# The Parish Councils of Assington, Bures St Mary, Leavenheath, Little Cornard, Polstead & Stoke by Nayland

## Interim combined response to Examining Authority's First Written Questions (ExQ1)

ELEVATION - B  
 SCALE 1:150

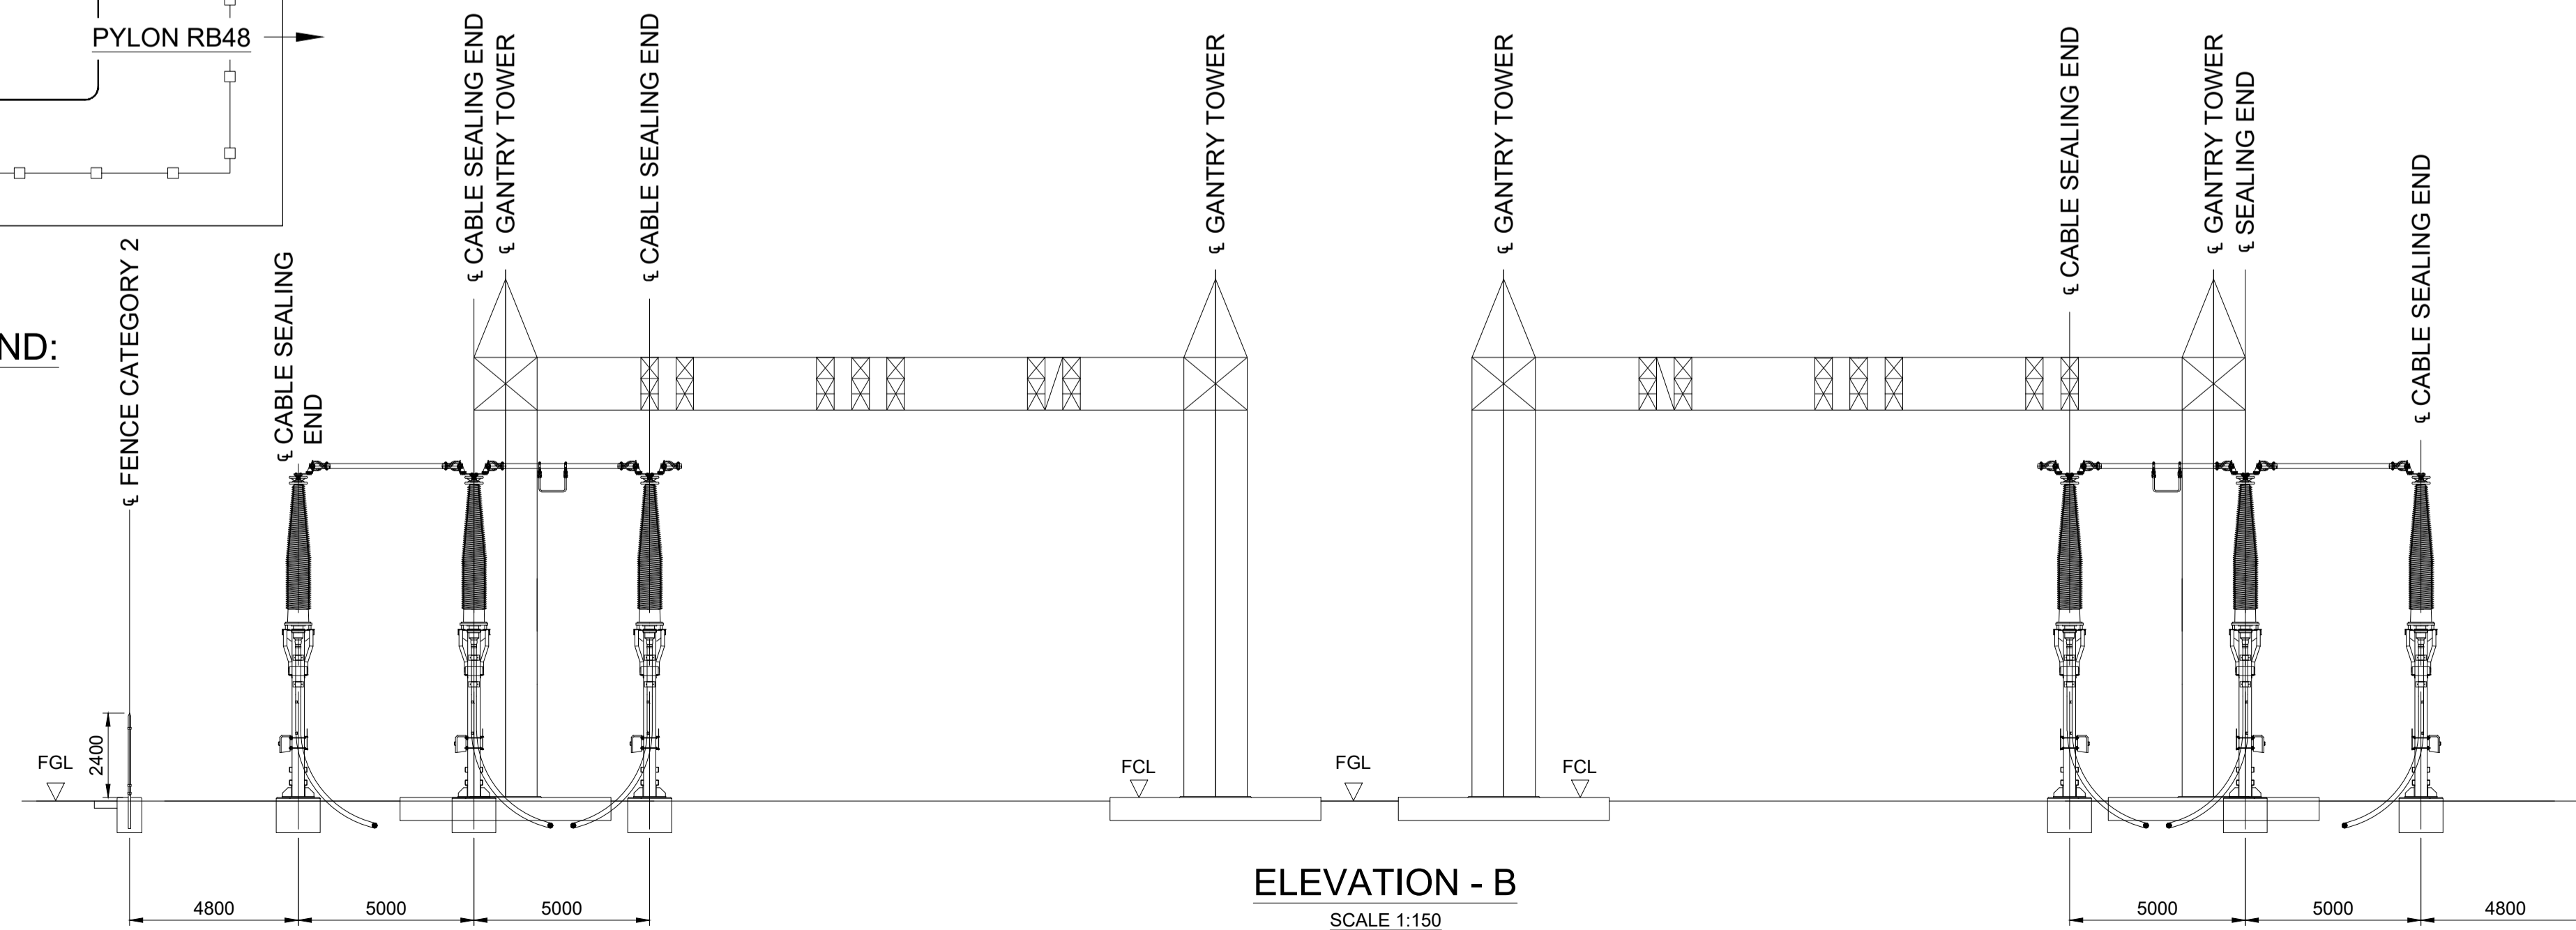
- 5.4 In addition, the Stour Valley East CSEC, while sited well to manage the impact of its visibility from the AONB, would have a permanent access road that would be highly visible from the SVPA, thus impacting its beauty and rural setting.
